East Anglia One North (EA1N) and East Anglia Two  
(EA2) Offshore Wind Farms

Planning Inspectorate Reference: EA1N – EN010077,  
EA2 – EN010078

East Suffolk Council's Responses to the Examining  
Authorities' Rule 17 Questions of 18 June 2021

Figure 1 Potential Sensitive Receptors and Areas Subject to Additional Construction Phase Controls

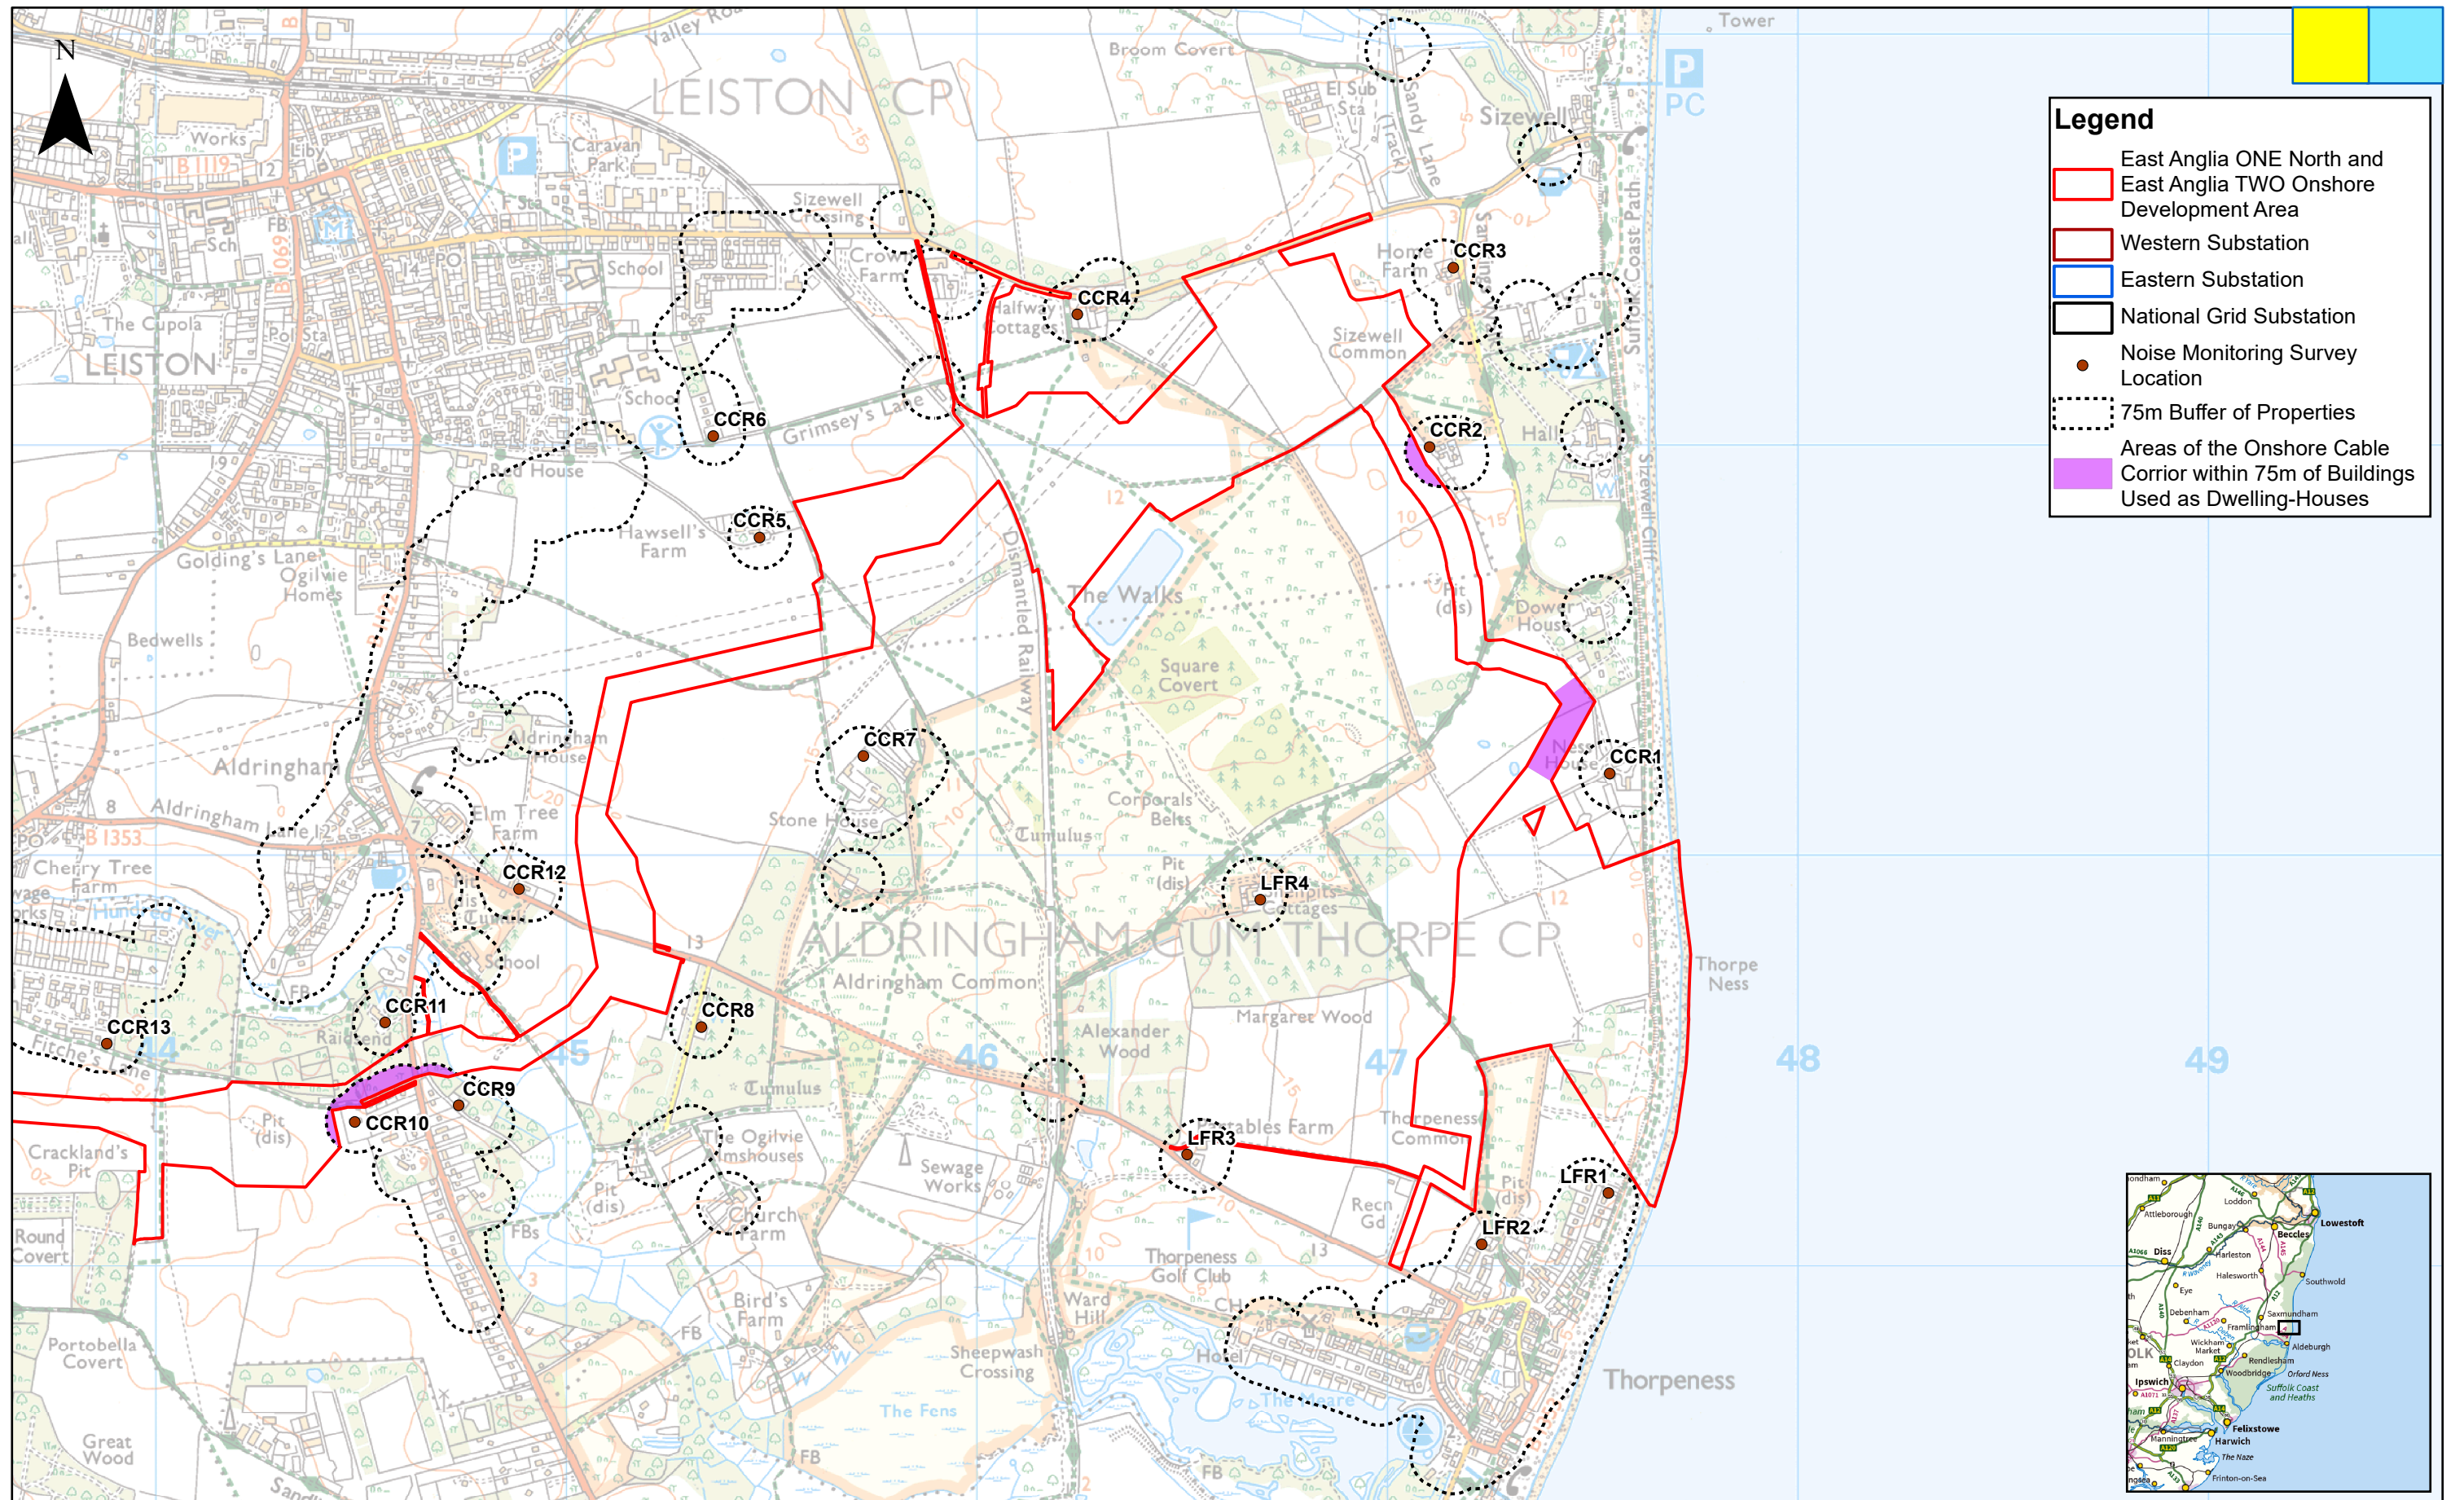
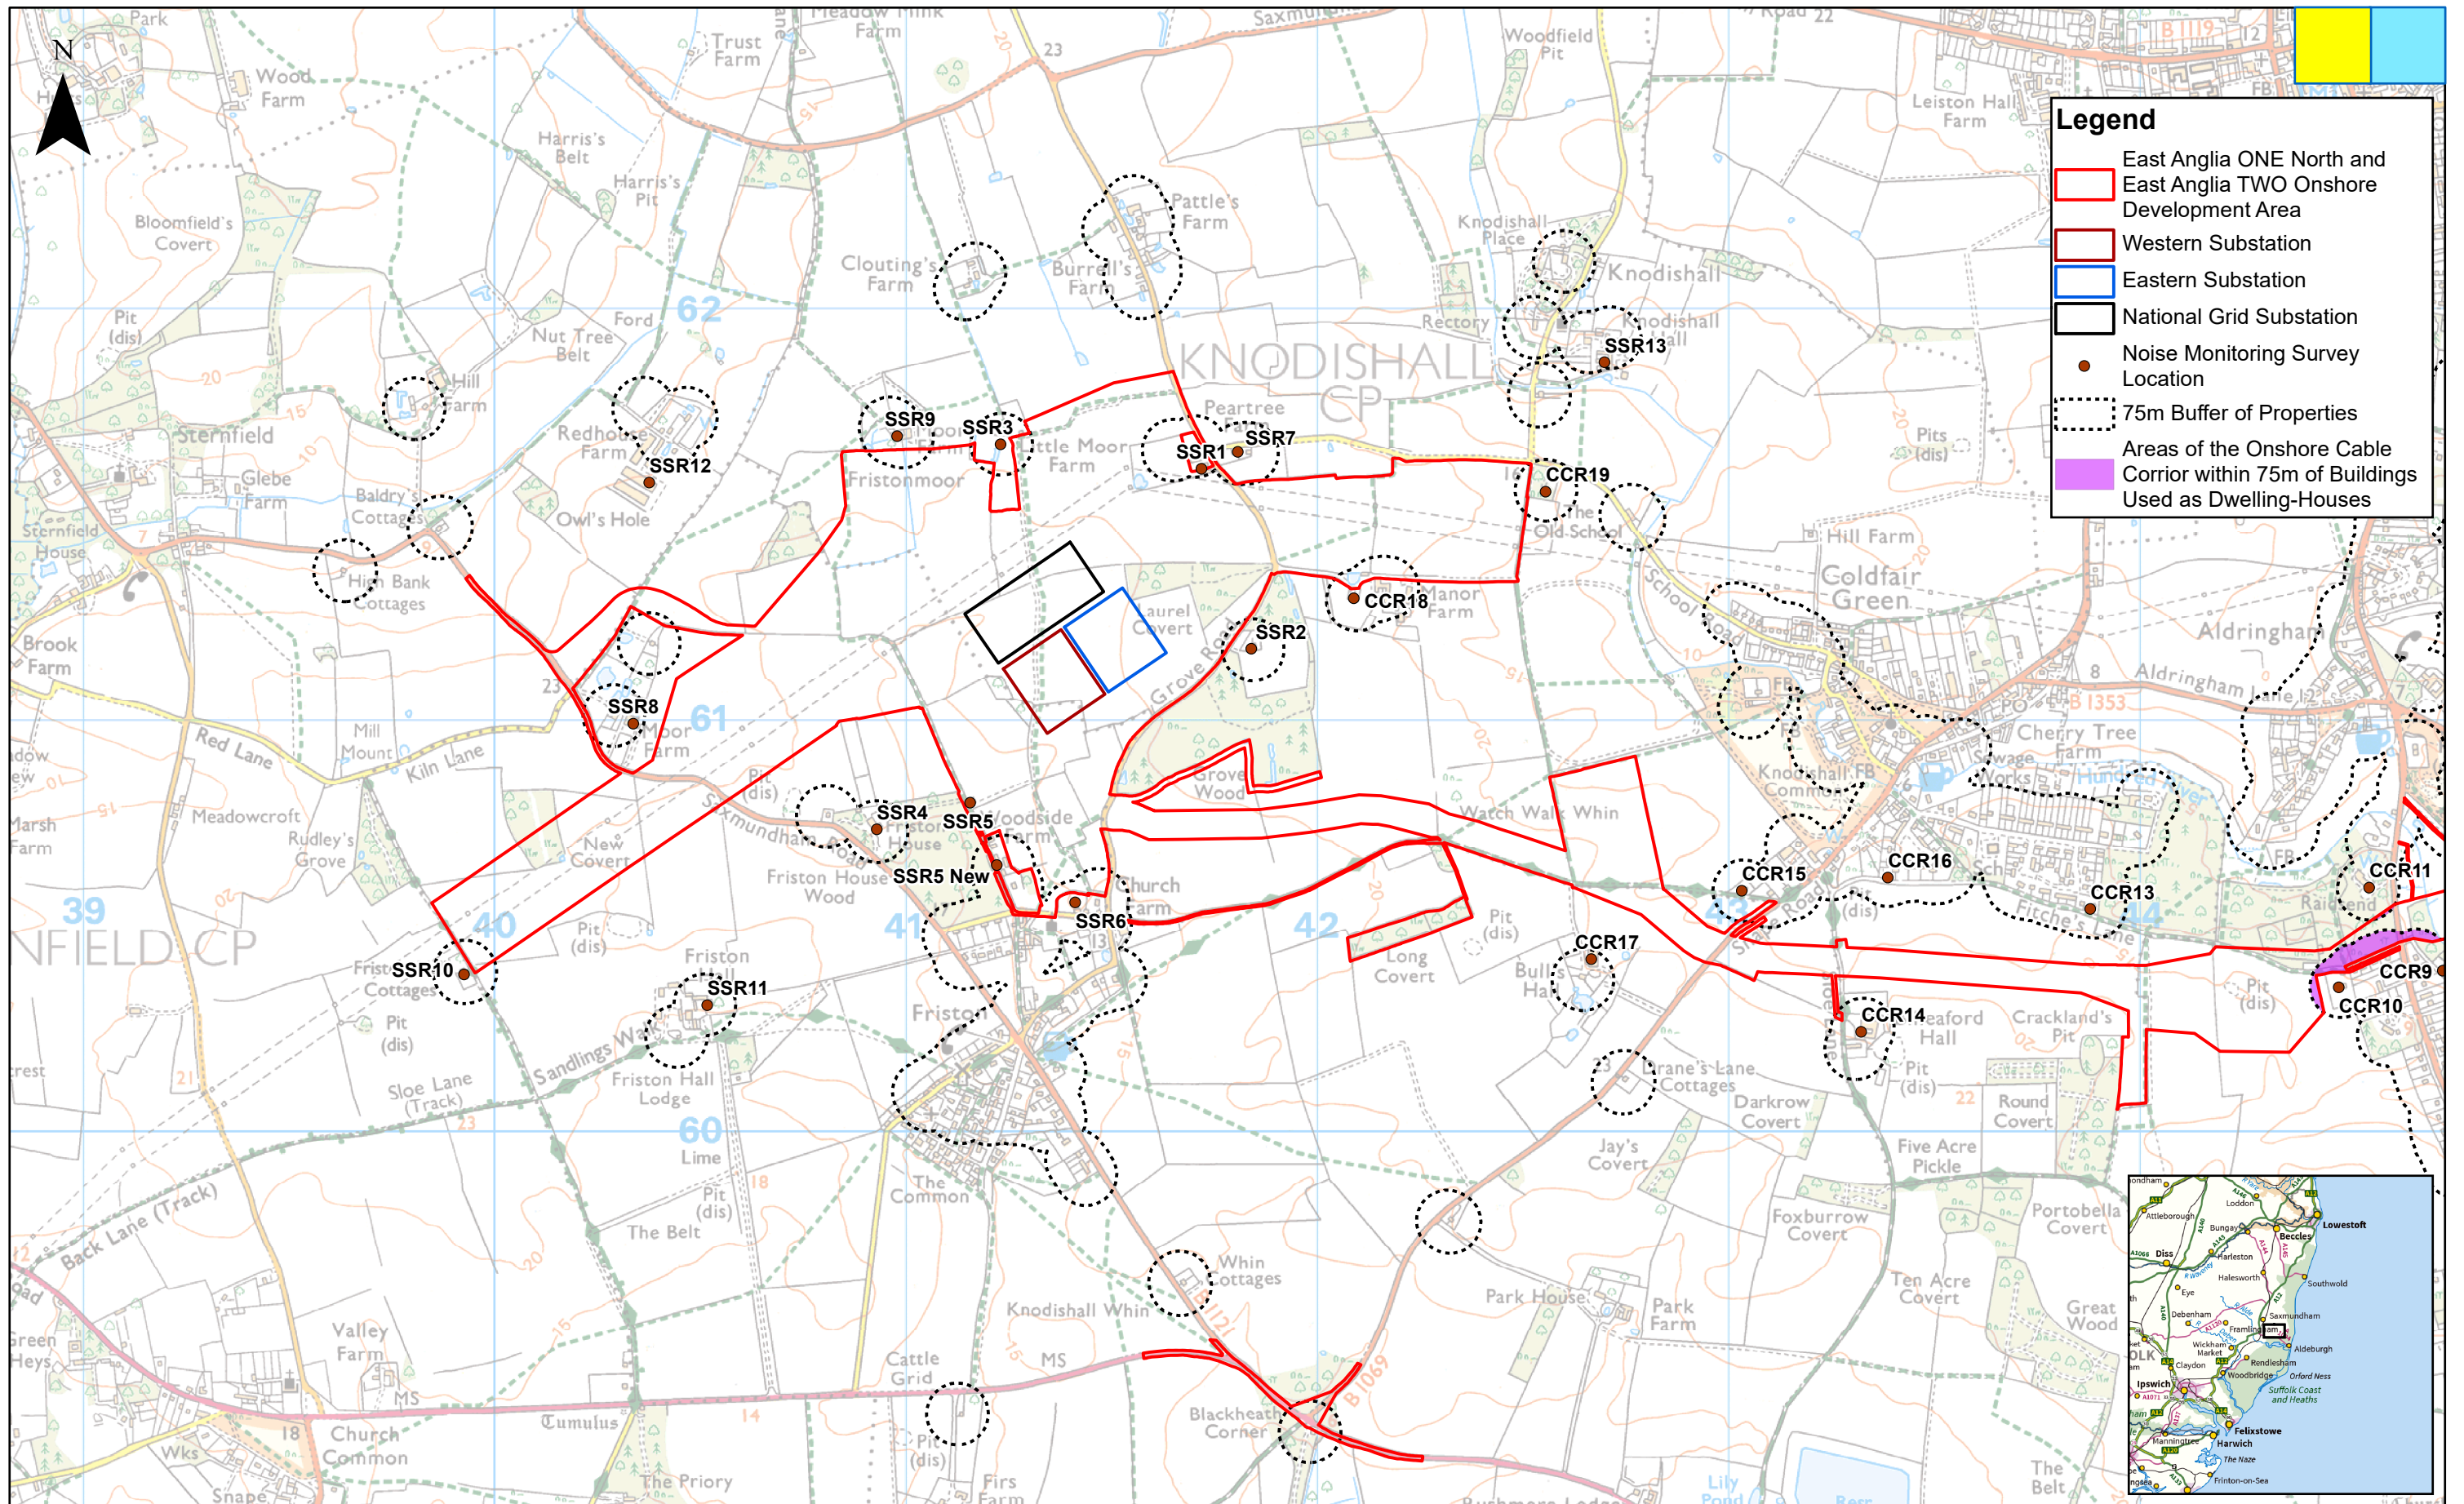
| R17QF. 10           | The Applicants, SCC, ESC, Historic England, SASES and any other | <p><b>Landscape and Visual Impact: Construction Drainage Management</b></p> <p>The Outline Code of Construction Practice [REP11-015] provides an example construction surface water drainage scheme at the Substations Location</p>  |  | <p>In relation to other construction activity, ESC does not consider that these temporary construction drainage basins will have any meaningful impact on the overall landscape and visual impacts arising during the construction phase. The only caveat to this would be if the substations were not built simultaneously but sequentially and any screen planting that was planted after a first phase was later disrupted or removed to achieve later phase</p>   |

|  | Interested Parties | <p>(Appendix 2, Figure 3). This is described in the text as a worst-case indicative general arrangement (para 176).</p> <ul style="list-style-type: none"> <li>• Provide any submissions you may wish to make on any impacts of this proposed construction surface water drainage scheme on matters of landscape, visual impact and the setting of heritage assets.</li> </ul> |  | <p>construction including temporary drainage provision. In such circumstances the mitigation benefit of initial new planting would be potentially severely set back, thus having an ongoing or indeed returning adverse impact on landscape character and visual amenity.</p> <p>The Outline Code of Construction Practice does not assess the potential impacts on the setting of the heritage assets. Notwithstanding this, as the temporary construction drainage basins would not have a meaningful impact on the structural landscape mitigation planting, ESC considers there would not be a notable impact on the settings of the heritage assets.</p> |
